18th June 2019

RE: Submission on Ivanhoe Estate Redevelopment – Stage 1 (SSD 8903)

Section AA\_

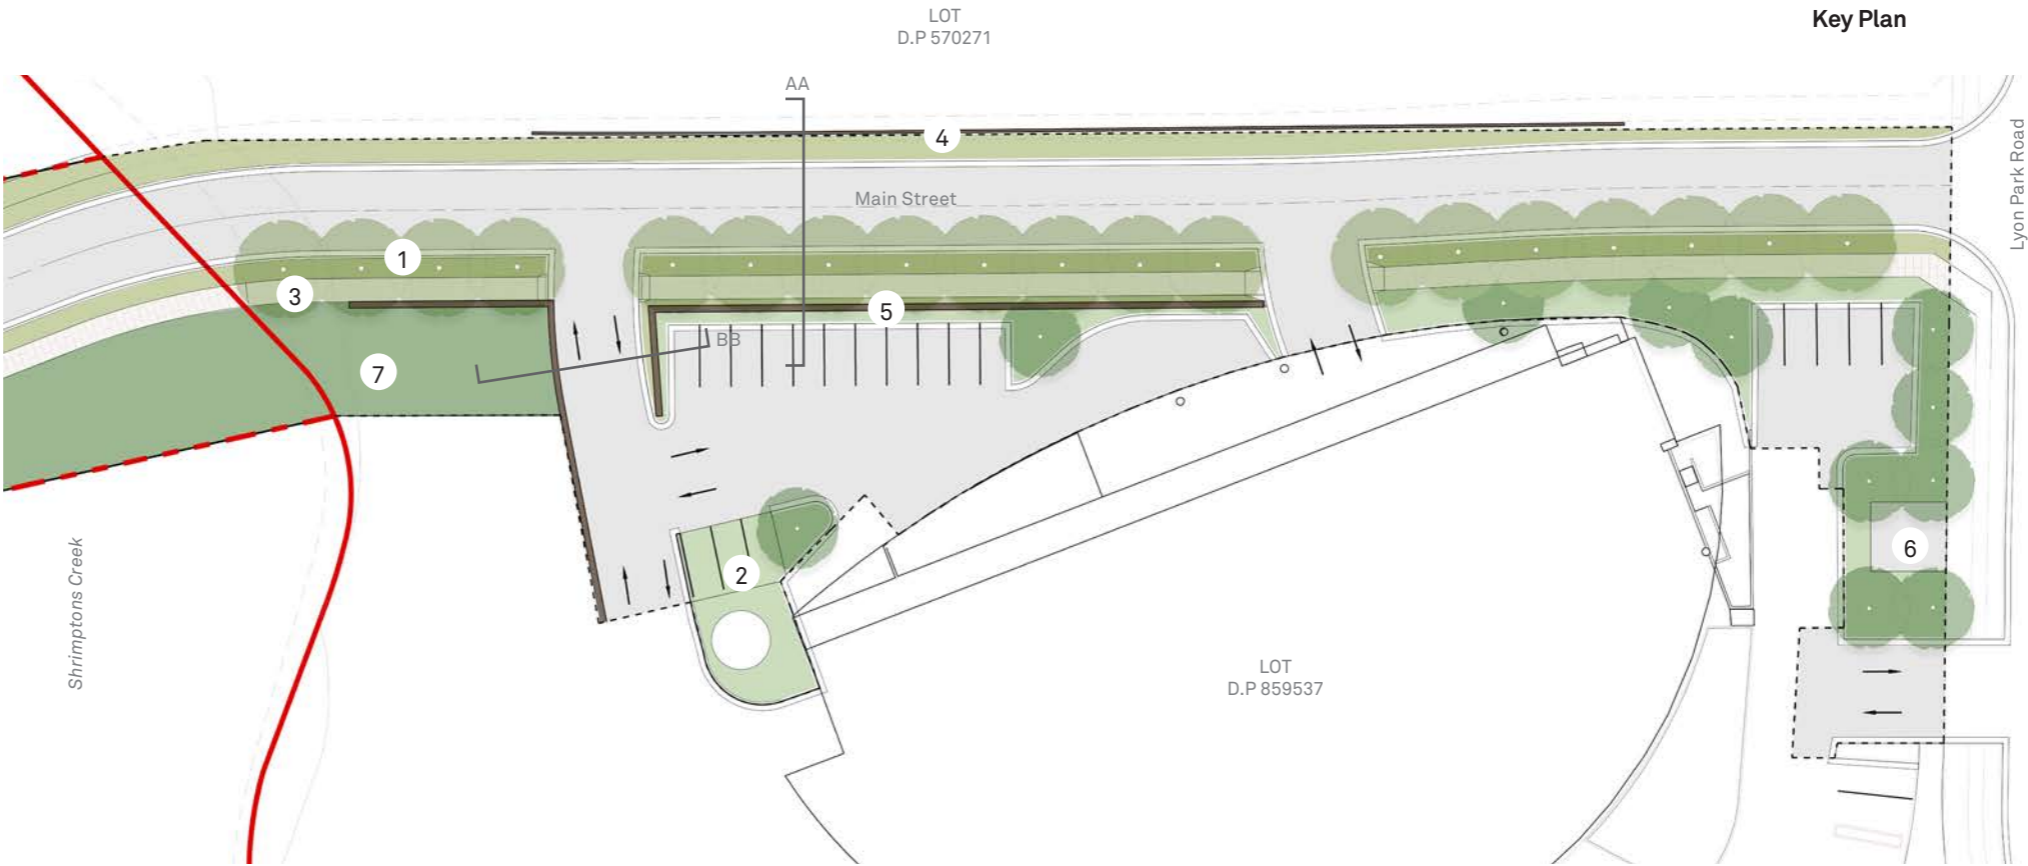
Adding to the confusion and general lack of clarity is the fact that the proposed screen is absent from the landscape layout of cross-section AA (Figure 2 below), which according to the previous layout (Figure 1), should include the proposed screen. Finally, there has been no indication of the dimensions of the screen (i.e. height, width and depth), its exact location nor the materials that will be used in its construction. Overall, this represents another major concern.
